SSD 17_8373

ALEXANDRIA PARK

RESPONSE TO

3 OCTOBER 2018
SA6700
REVISED FINAL
PREPARED FOR NSW DEPARTMENT OF EDUCATION

3 WINTER 3PM
1 : 1000

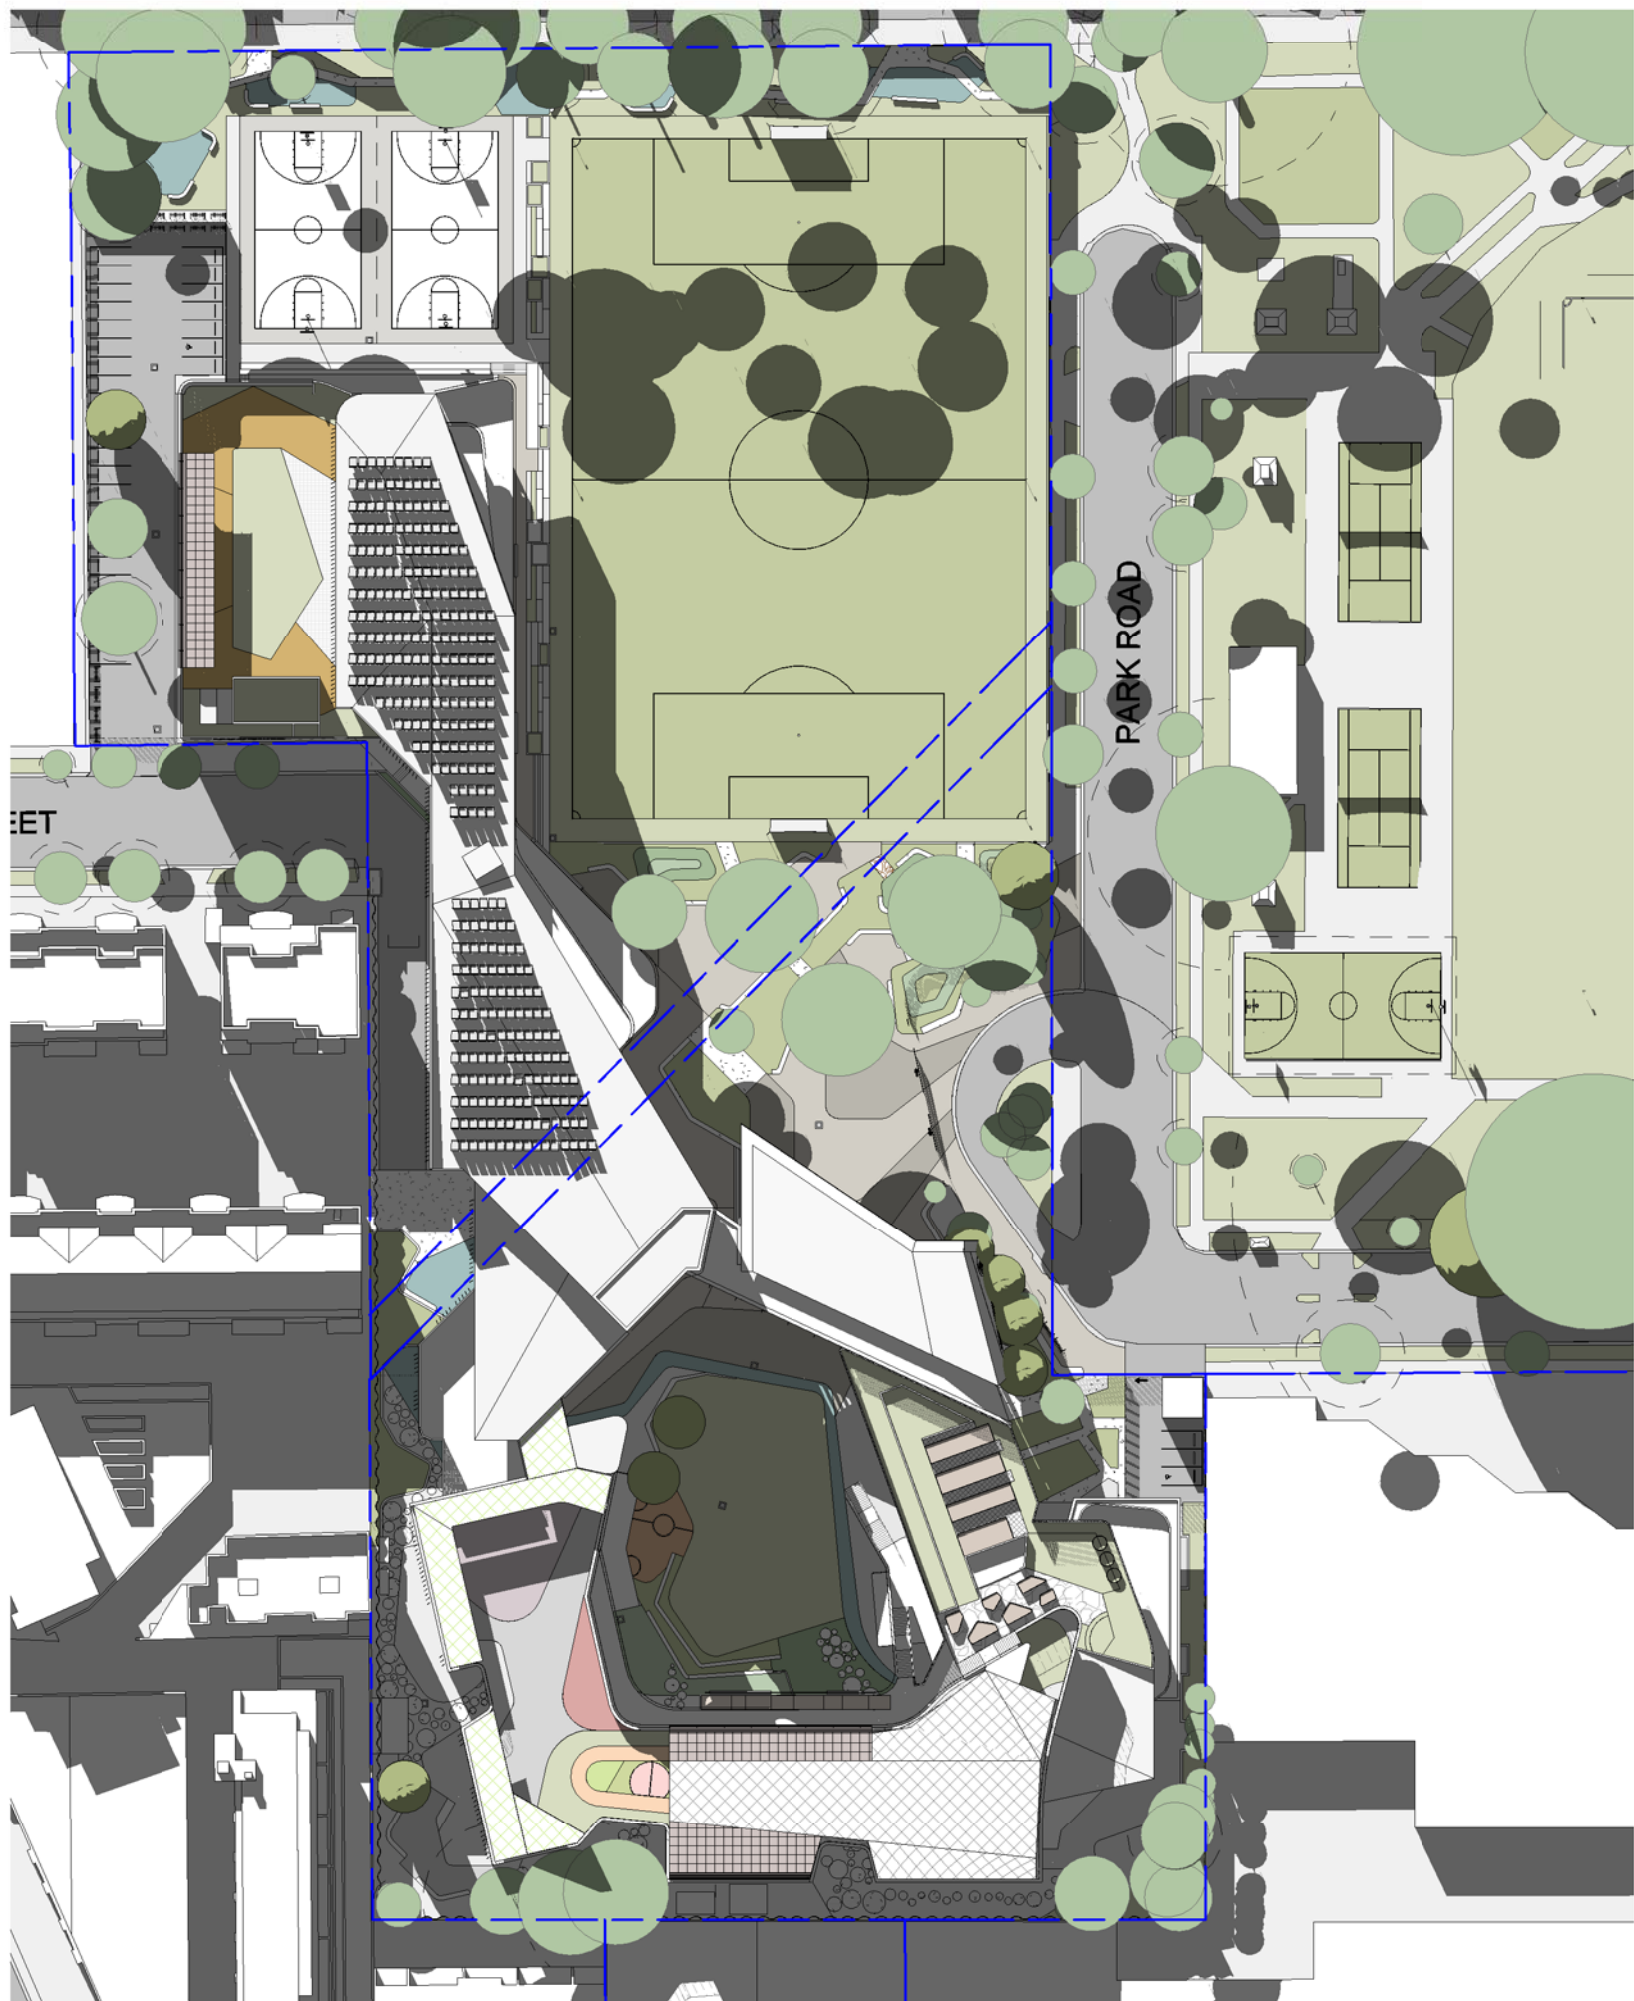
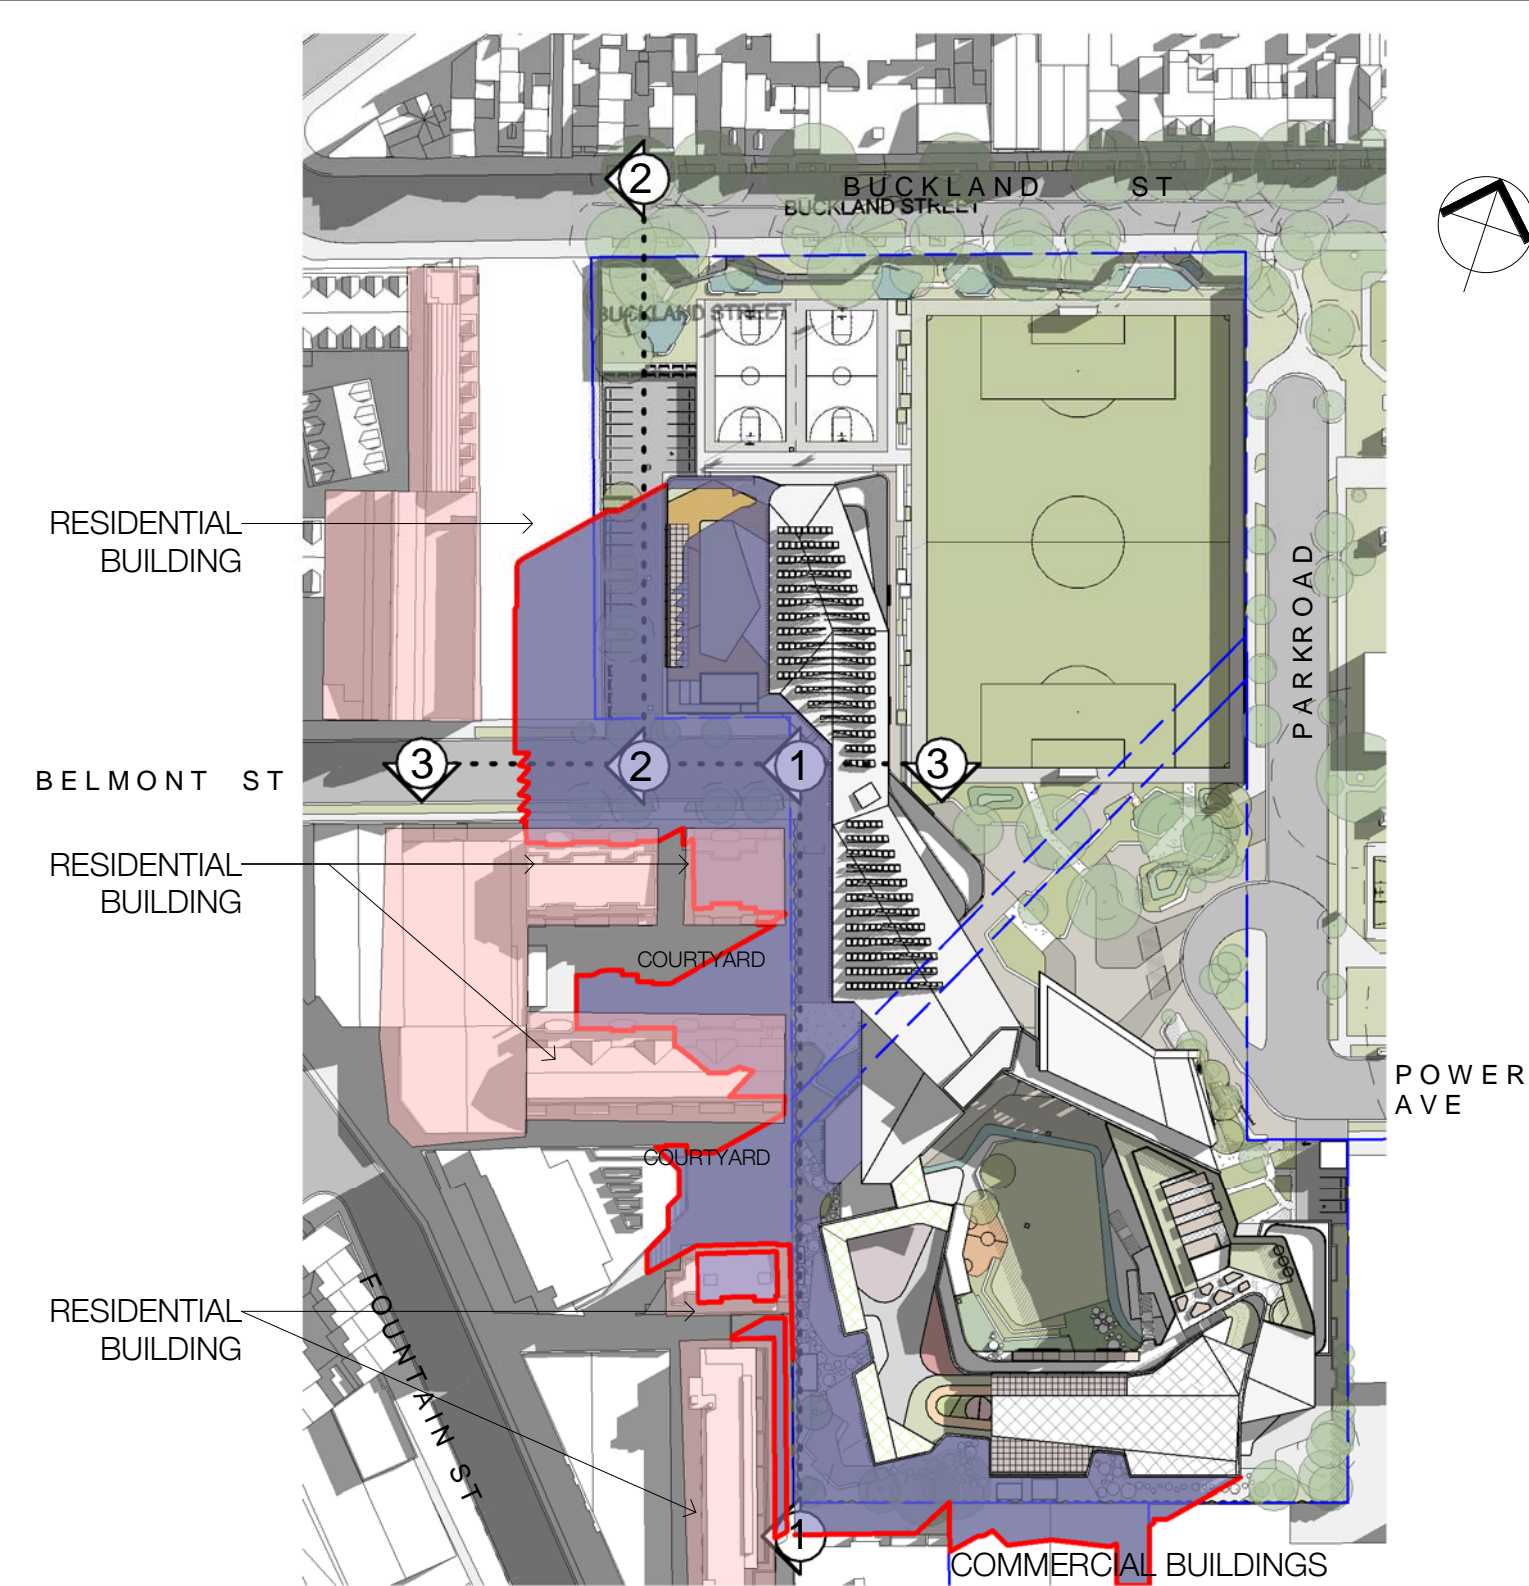
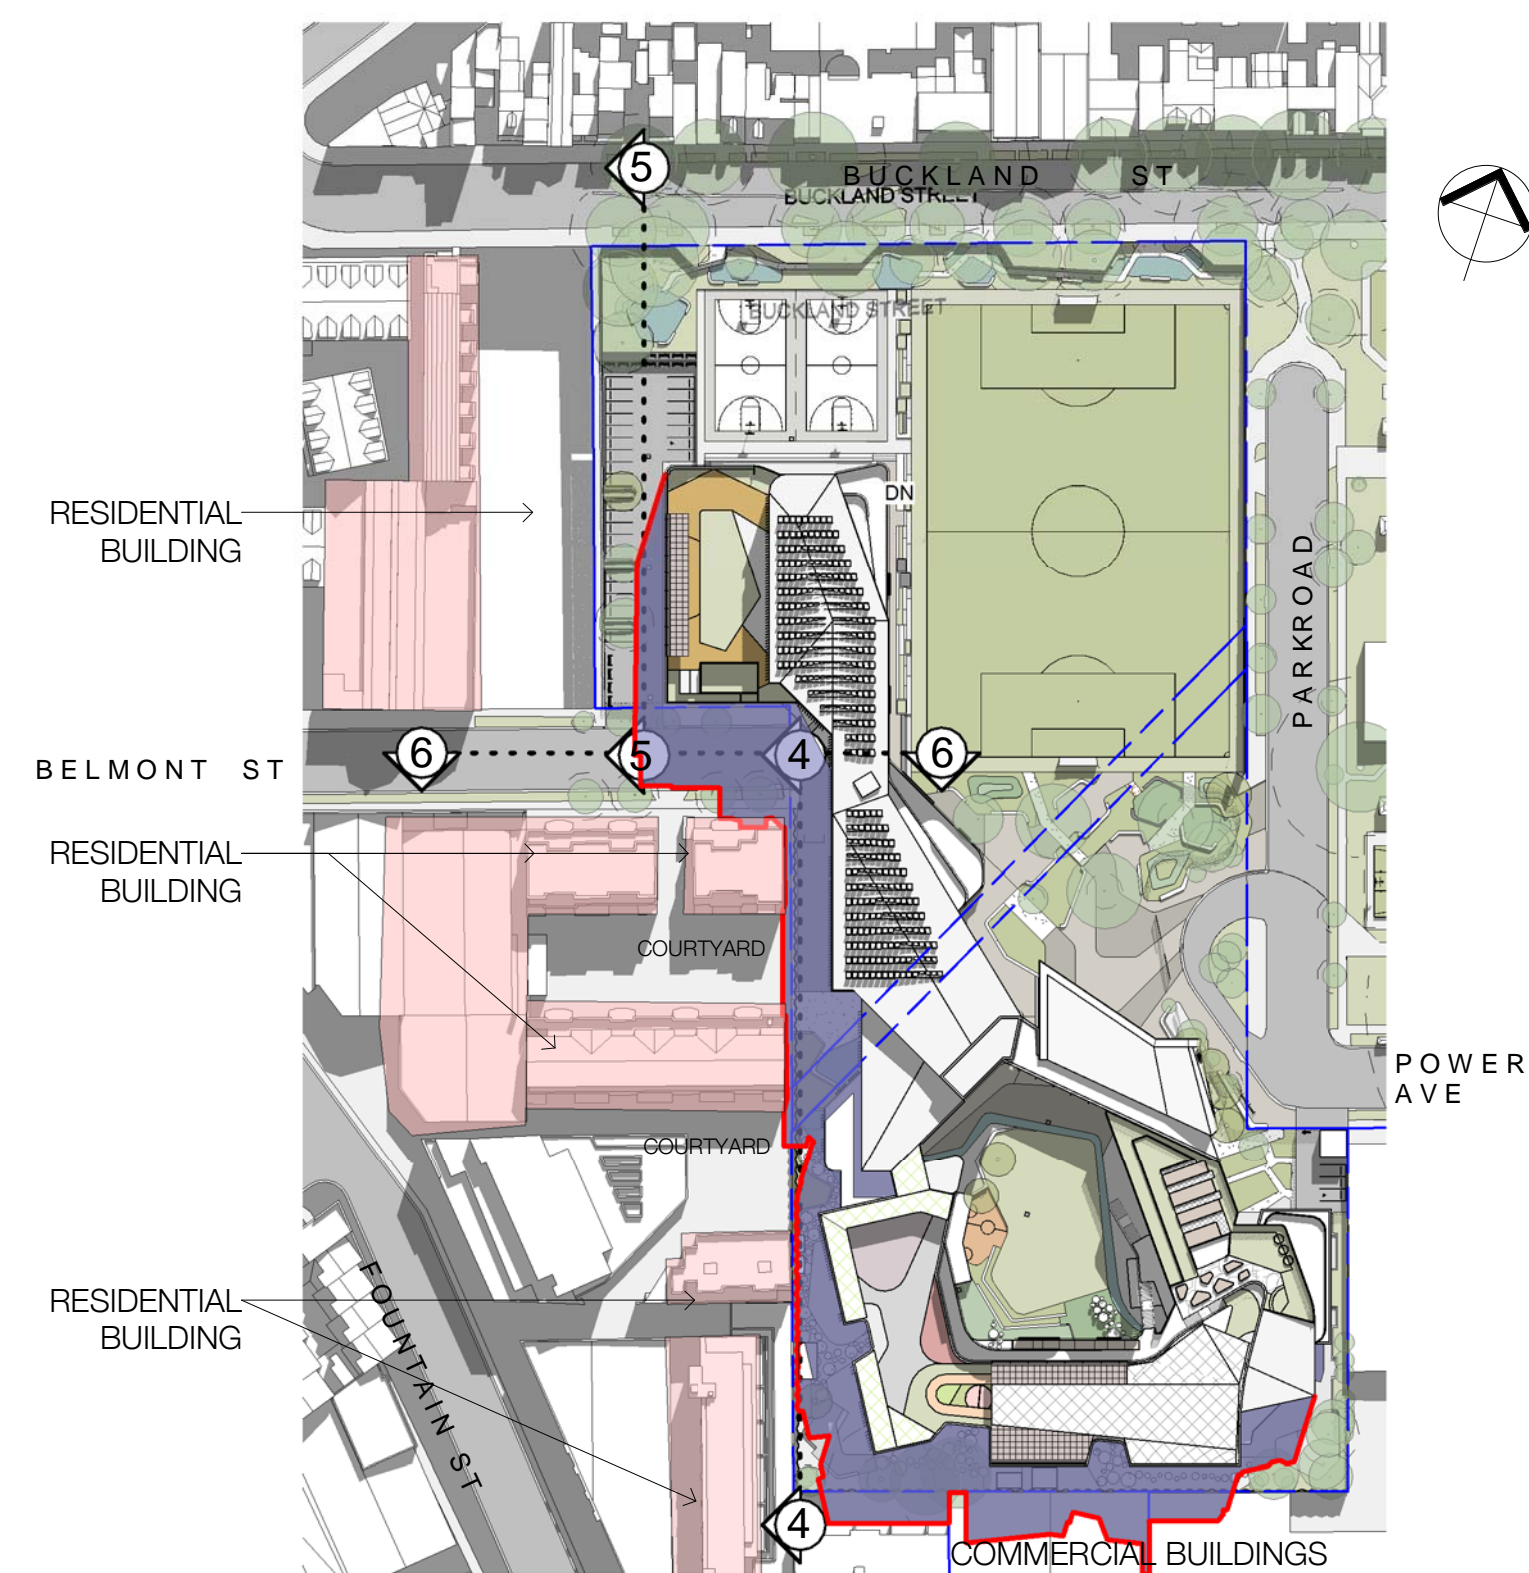
4. Overshadowing	<ul style="list-style-type: none"> The Department notes the comments of the Council regarding overshadowing. Section 6.2.3 of the EIS and Drawing Nos AR.DA.5001 and AR.DA.5002 do not adequately address or depict the shadow impacts of the proposed development upon adjacent properties. 	Refer to the updated Architectural Plans and Urban Design Report at Appendix B and Appendix D respectively for detailed shadow analysis, which is described in Section 3.1 of this RtS report.	Section 3.1, Appendix B and Appendix D

5. Overshadowing	<ul style="list-style-type: none"> A revised assessment of overshadowing impacts at hourly intervals between 9am and 3pm should be provided, including but not limited to: <ul style="list-style-type: none"> more detailed aerial plans detailing existing, height compliant and proposed shadow impacts; and more detailed elevations of affected properties depicting existing, height compliant and proposed shadow impacts and affected windows and room use. 	Refer to the updated Architectural Plans and Urban Design Report at Appendix B and Appendix D respectively for detailed shadow analysis, which is described in Section 3.1 of this RtS report.	Section 3.1, Appendix B and Appendix D

TKD have amended the proposal to improve solar access to 58-60 Belmont Street when compared to the original SSDA. Figure 3 illustrates by shifting the proposed hall 3m north, the Belmont Street building receives much more sun at 2pm in mid-winter. An hour-by-hour analysis of sun access to the northern facing apartments is detailed in Table 1. The table shows that Units 1, 2, 3, 17 and 18 will receive an additional 1-2 hours of sun with the amended proposal. Overall, all apartments will receive at least 2 hours of solar access in mid-winter. This is consistent with the Apartment Design Guide (ADG) and Sydney Development Control Plan 2012 (SDCP). The amended proposal is therefore an improvement and addresses community and agency submissions. This is discussed in more detail in Section 4 of this RtS.

TKD have modulated the primary school home bases to allow greater solar access to 141-143 in response to public submissions. The amended proposal achieves 2 hours of solar access between 9am and 3pm at mid-winter to 17 of the 18 north facing apartments. Unit 8 will receive 1.5 hours of solar access. This is an additional hour when compared to the original SSDA. On balance, the proposed shadow impact is not unreasonable. The amended proposal achieves 2 or more hours of solar access to 95% of north facing apartments, which complies with the ADG and SDCP. The proposal provides significant community and social infrastructure and, on balance, the amended design maintains appropriate level of amenity to adjoining properties.
